# Consultee Comments for Planning Application 2026/90791

Application Number: 2026/90791

Address: 350 Huddersfield Road, Mirfield, WF14 9DQ

Proposal: Change of use of furniture manufacturer and upholsterer to mixed-use site comprising ground floor retail E(a) and cafe E(b) and first floor acting/education class F1(a) including theatre and dance hall (sui generis)

PROJECT TITLE			
MIRFIELD LITTLE THEATRE			
DRAWING TITLE			
General Arrangement GROUND & FIRST FLOOR			
SCALE	DRAWN	CHECKED	PROJECT REP
1:50 at A1	dn	Lou	0178
PAPER SIZE	DWG NUMBER	DATE	REVISION
A1	(20)002	March 26	B
CLIENT DETAILS			
MIRFIELD LITTLE THEATRE

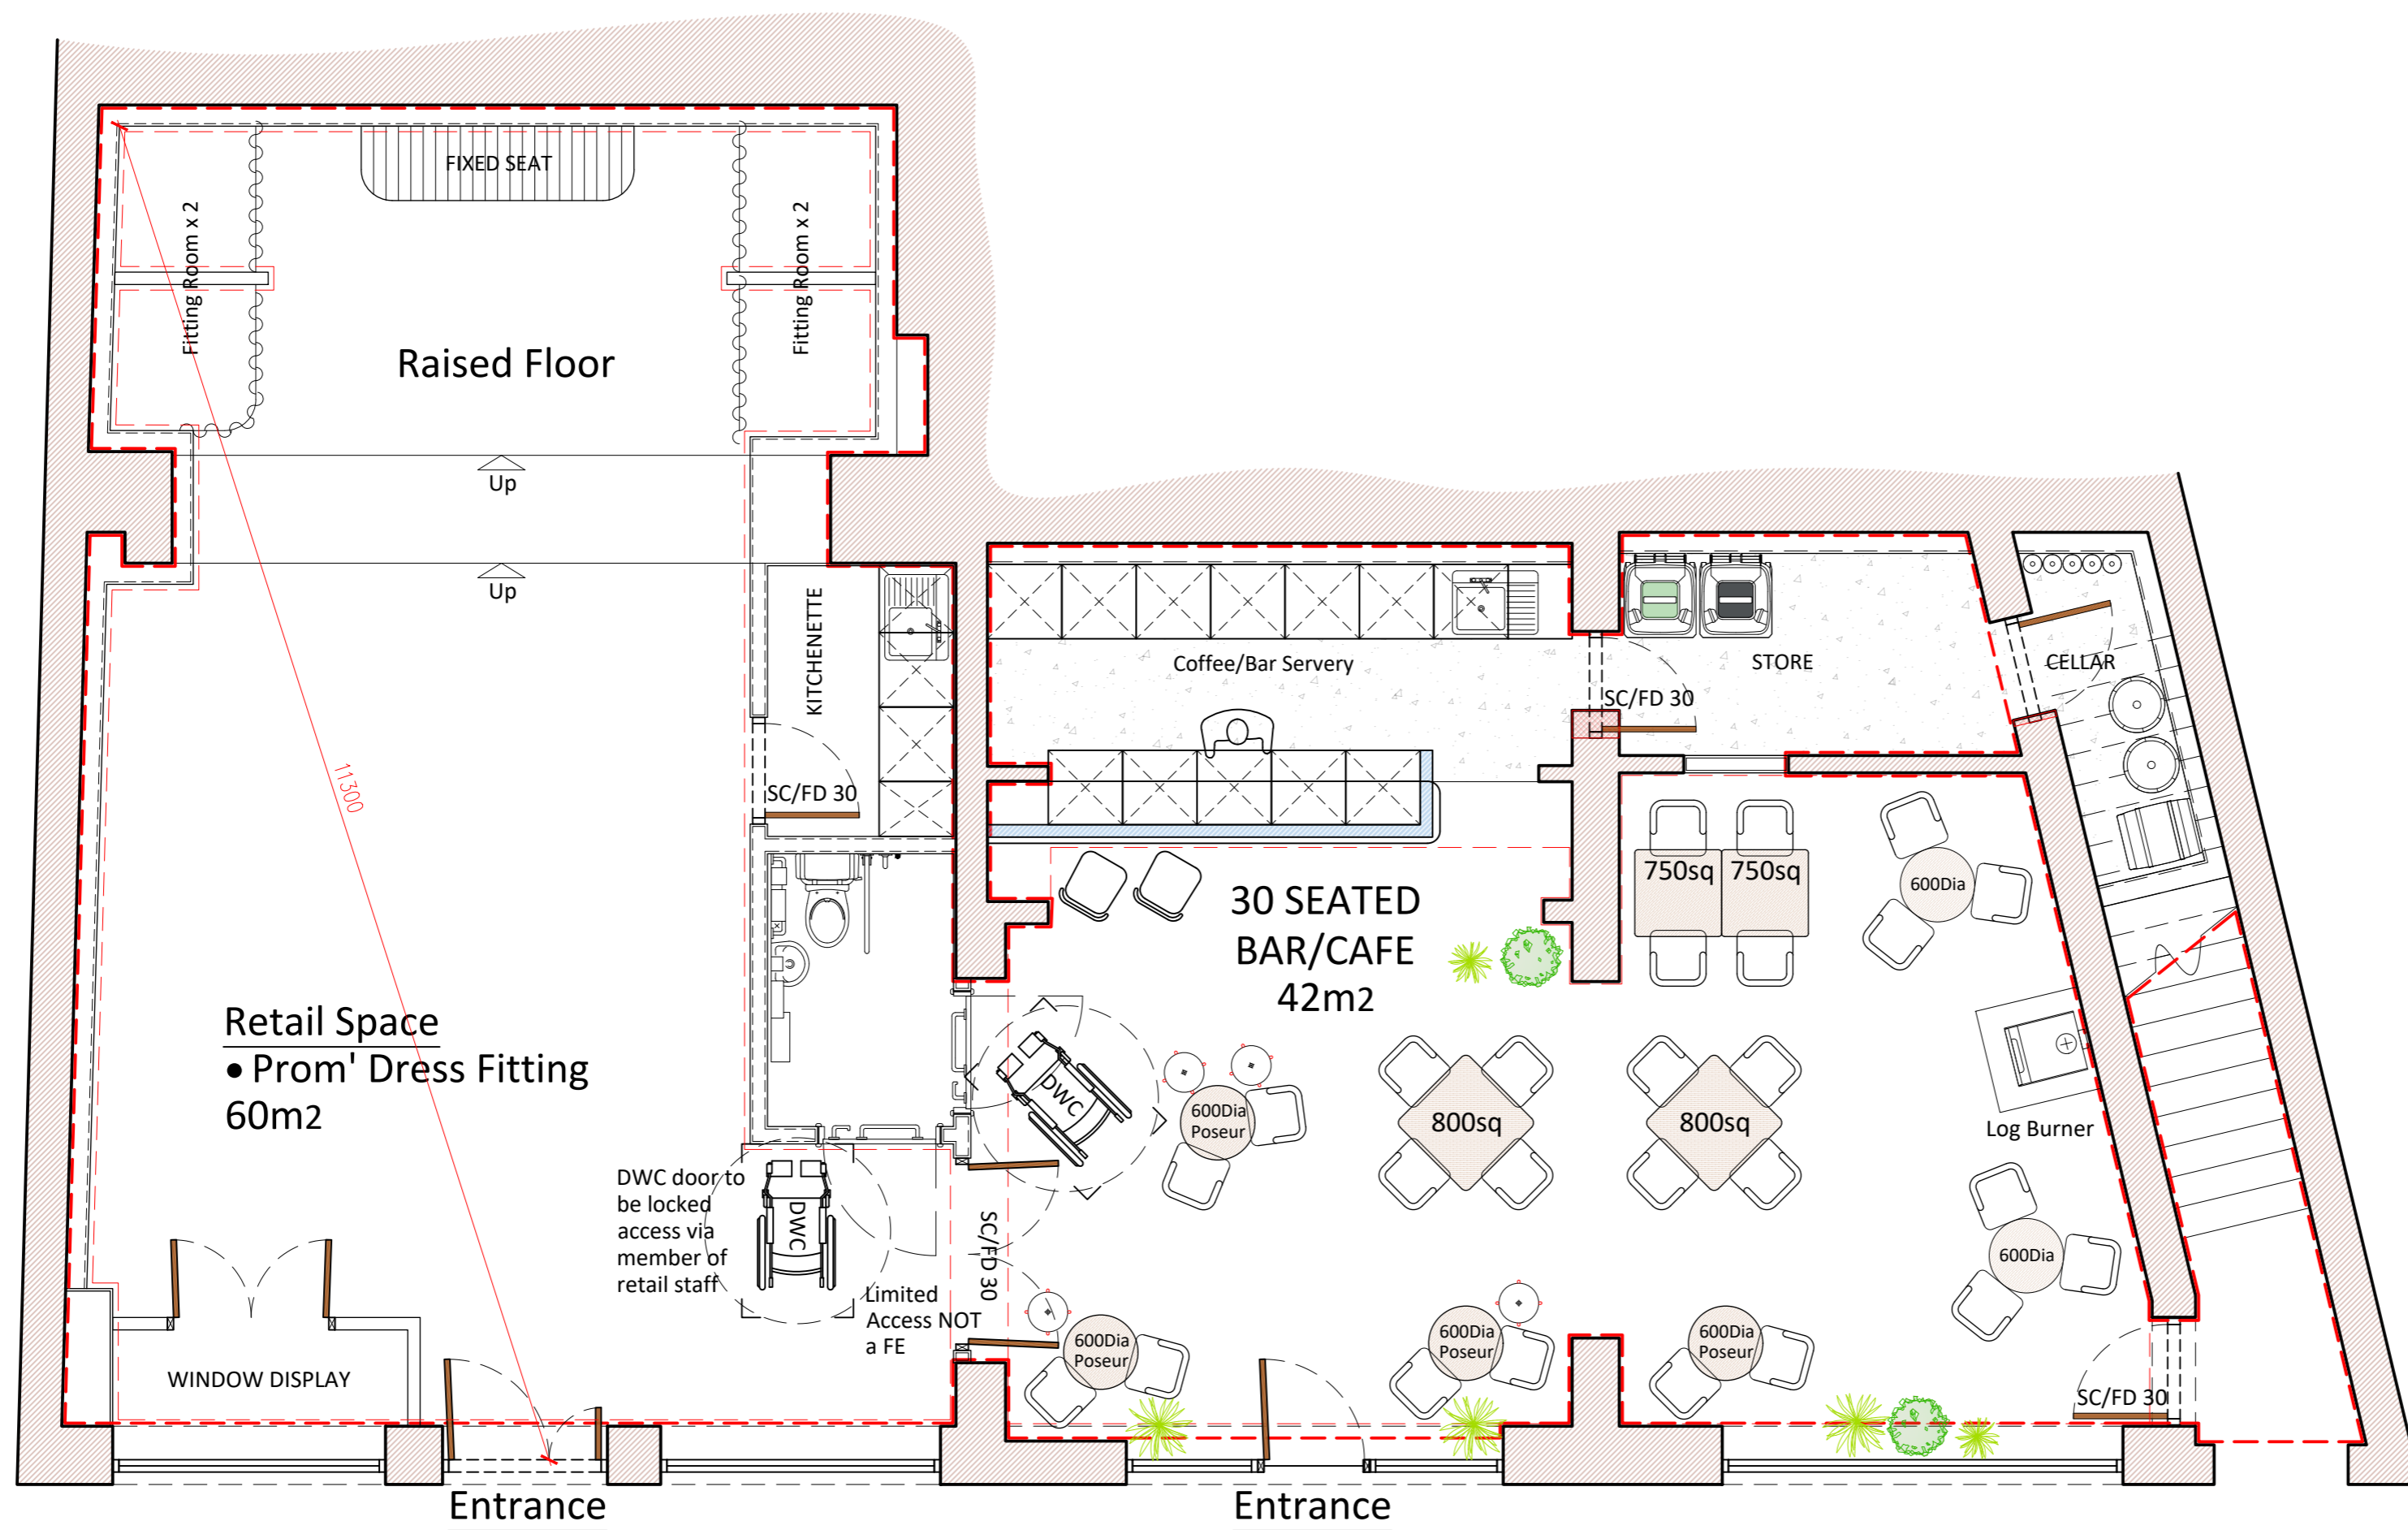
The proposal is to change the use of 350 Huddersfield Road, Mirfield, WF14 9DQ to mixed-use including retail and café on ground floor, with acting/ education class, theatre performance area and dance hall on the first floor. No external alterations are proposed.

Looking at the site and its current surroundings, I am of the opinion that the proposed use would stand in conflict with the current character of the area, result in overintensification of the site's use and have a negative impact on the immediate neighbours.

I note the comments amongst the public representations which cite concerns over highway safety, pedestrian safety, impact on residential amenity and lack of local infrastructure to support the proposed new use. I agree with these concerns and believe that the proposed new use is too intense for this particular site. However, I appreciate that the impacts on highway safety and parking would be for Kirklees Council to assess and determine as appropriate.

Pedestrian safety should also be considered. The new use could result in a large volume of people exiting the venue onto a fairly narrow pavement which immediately abuts a 40mph road. Additional street furniture could assist in mitigating this issue and directing the foot traffic appropriately.

Should the LPA be minded to approve it, we would respectfully request the inclusion of a planning condition for security measures in the interests of crime prevention and community safety.
